**Subject:** FG/59/20/HH - Request for further information

This email is regarding the application proposed at 10 Highdown Way, Ferring.

Client: Mr. P Simpson
Site: 10 Hlghdown Way
 Ferring
 West Sussex
Description: North & South Elevations
Drawing No.: HD 20003
Scale: 1: 100 @ A3

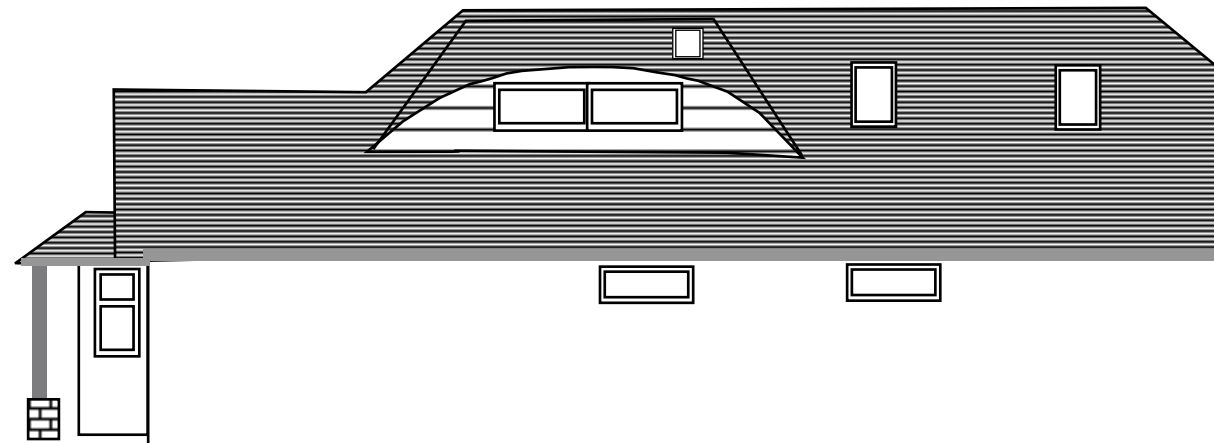
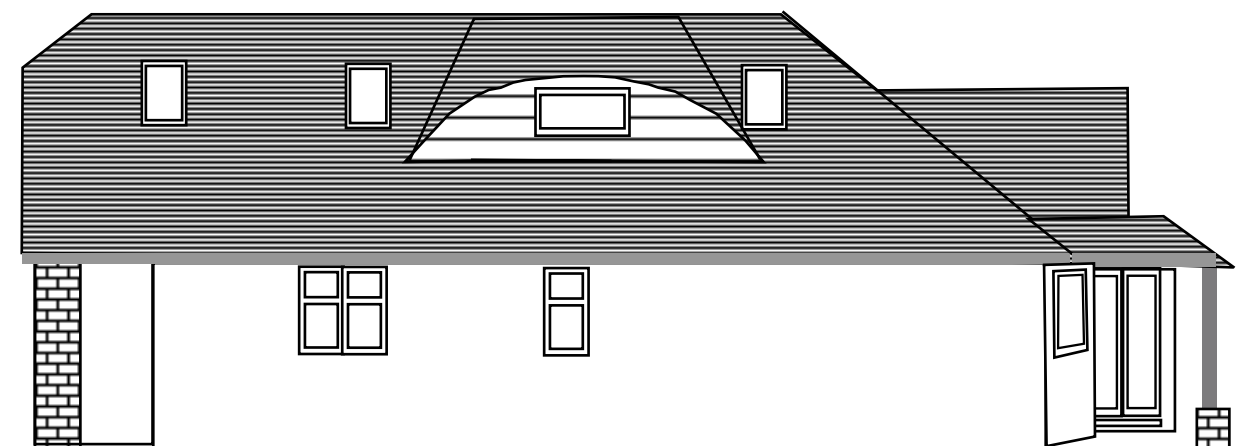
How high above the internal floor level are the proposed rooflights?
